Application number: 2025/93355	
What is the application for?:	Erection of 75 residential dwellings with associated landscaping, open space, hi
Address of the site or building:	Land off, Woodward Court, Mirfield, WF14 0PY
Postcode:	LS15 8ZB

Type of comment: An objection	
Do you wish your comments to be published on the website anonymously?	Yes
subject: Objection to Planning Application 2025/93355 – Proposed Residential Development off Woodward Court / Hepworth Lane I am writing to formally object to planning application 2025/93355, concerning the proposed residential development on land off Woodward Court and Hepworth Lane. Although new plans have been submitted, the changes do not address the fundamental technical concerns raised on the December 2025 proposals. It must be noted that the supporting information remains largely unchanged. Drainage Although the design appears to have settled on surface water being dispersed via an infiltration basin rather than a balancing pond connected to the existing drainage network it does not appear to have addressed the fundamental requirement to undertake a hydro-geological study to confirm the suitability of an infiltration basin. It is uncle

DRAWING NUMBER: **49653 - ECE - XX - XX - DR - C - 0016** REV: **P06**

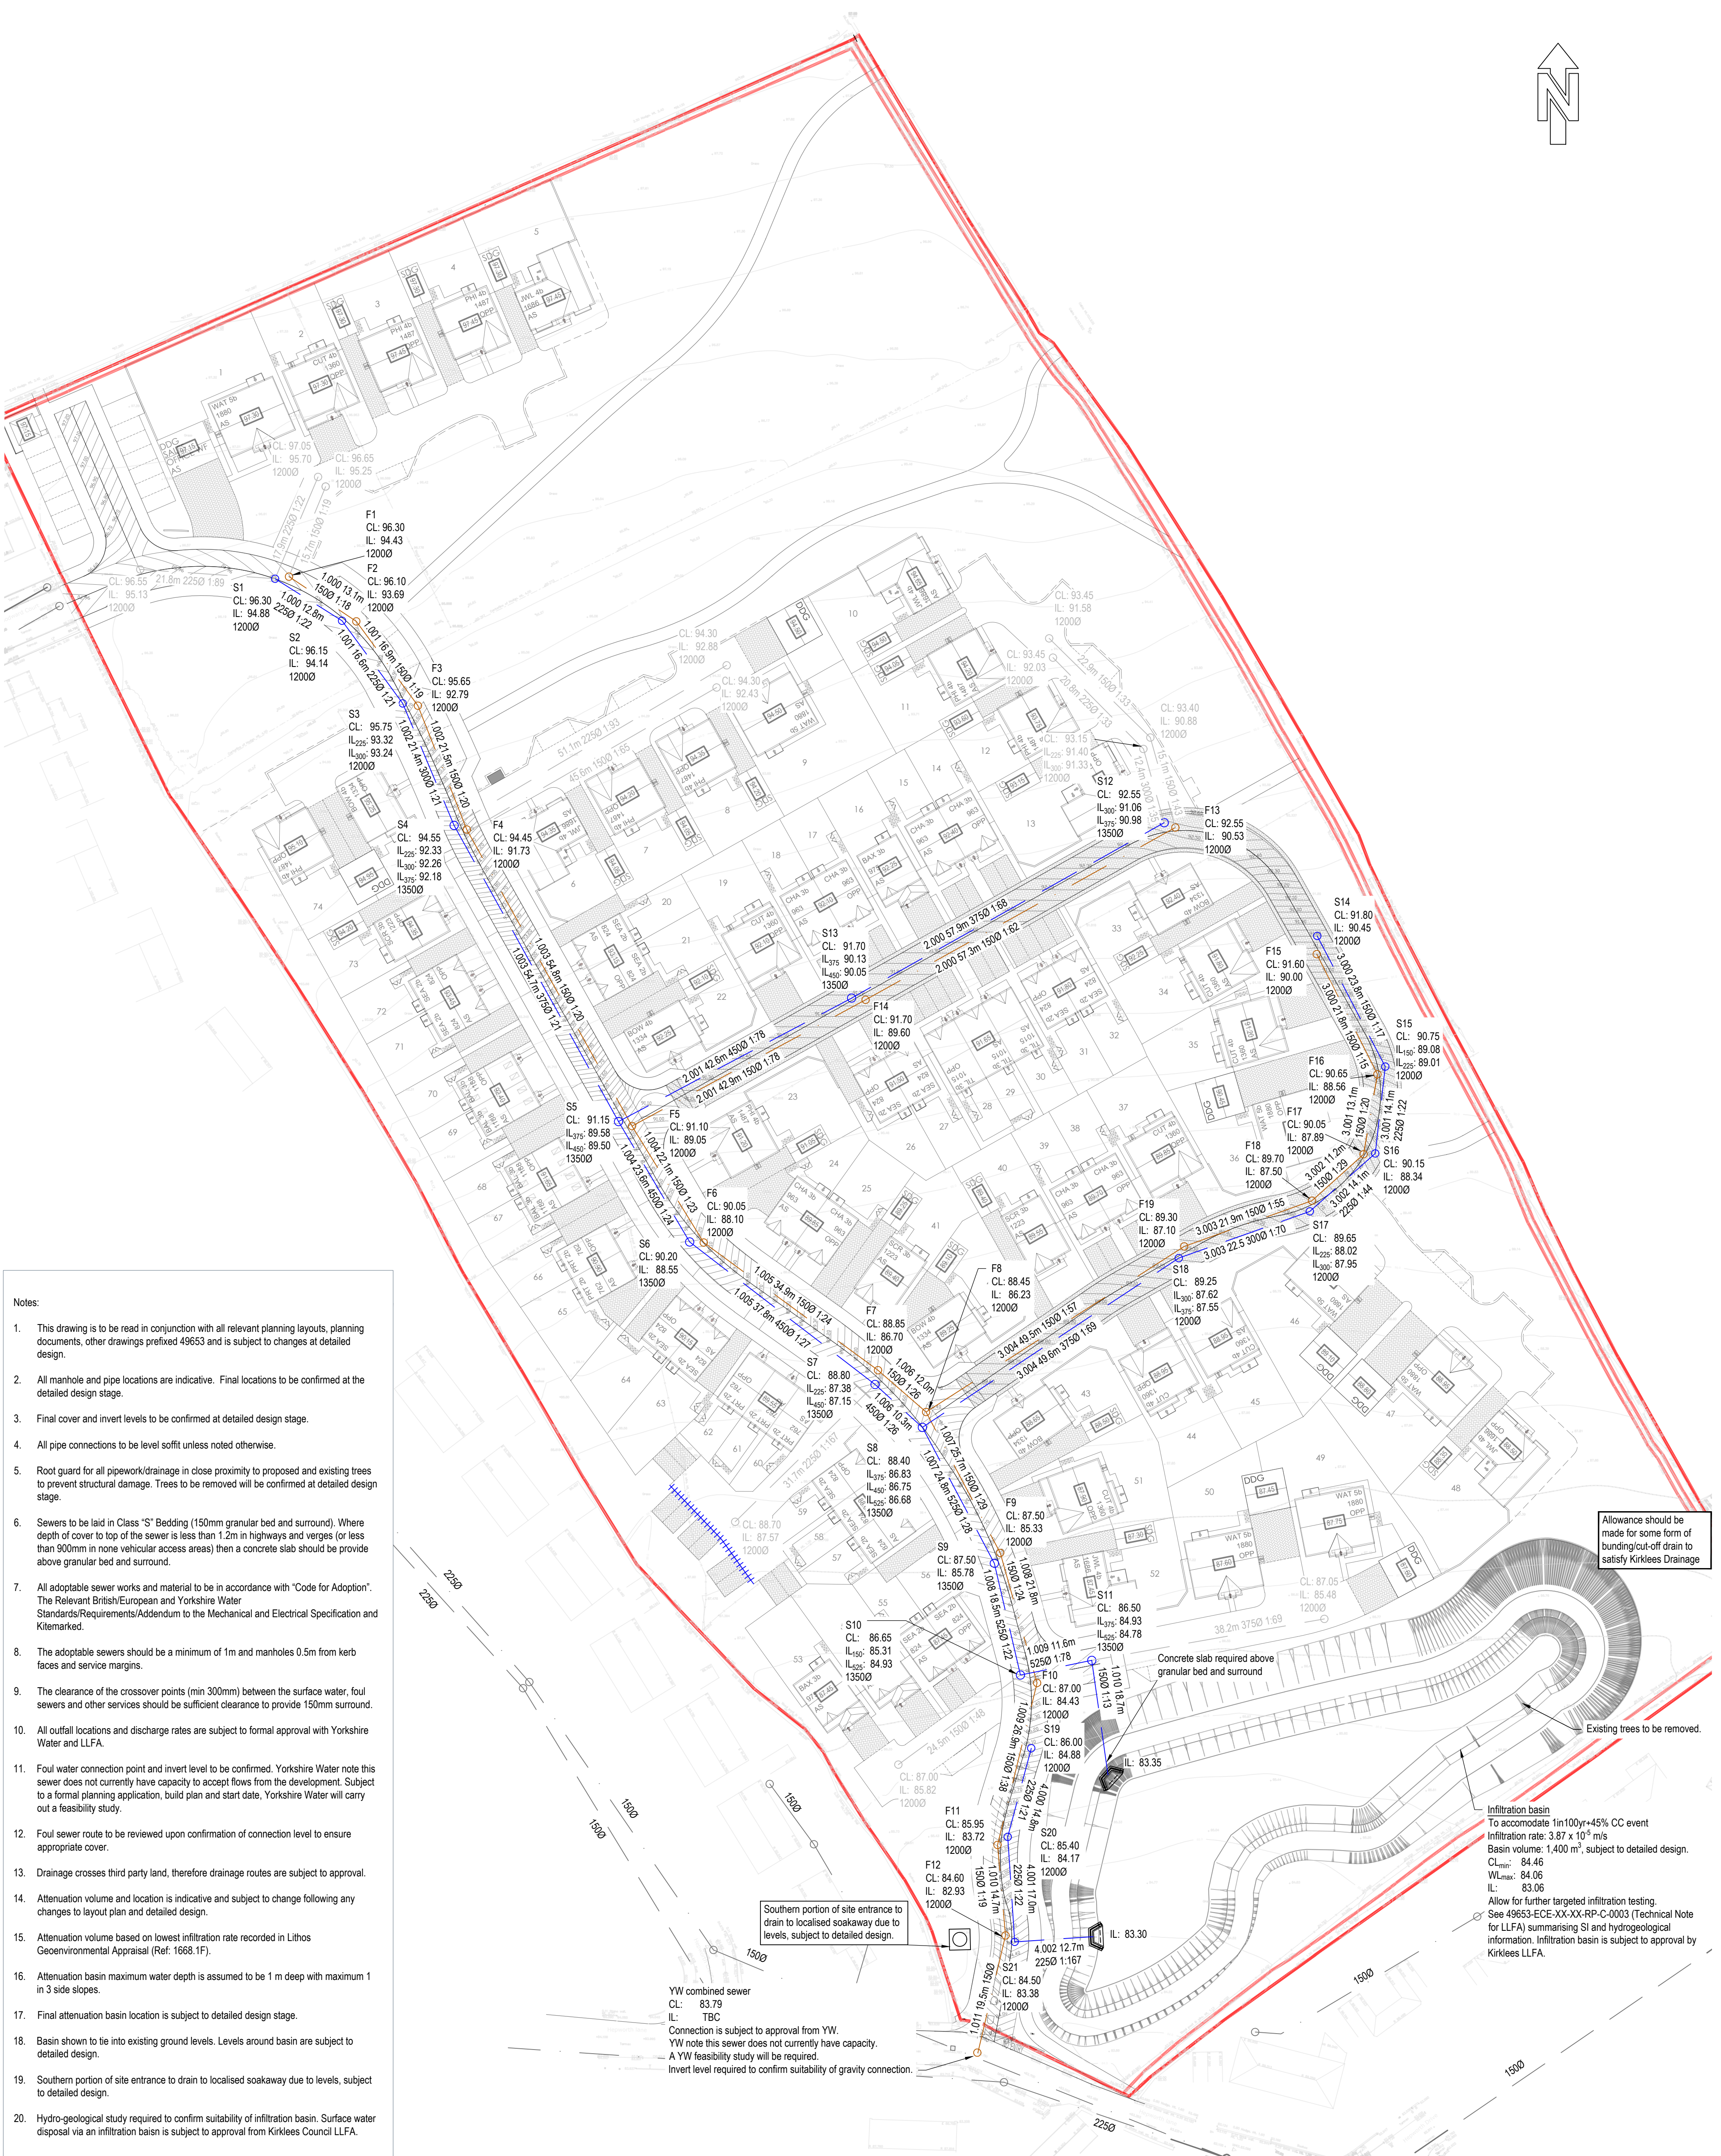
sewerage network on Hepworth Lane remains. Any upgrade of the sewer in Hepworth Lane would considerably inconvenience local residents.
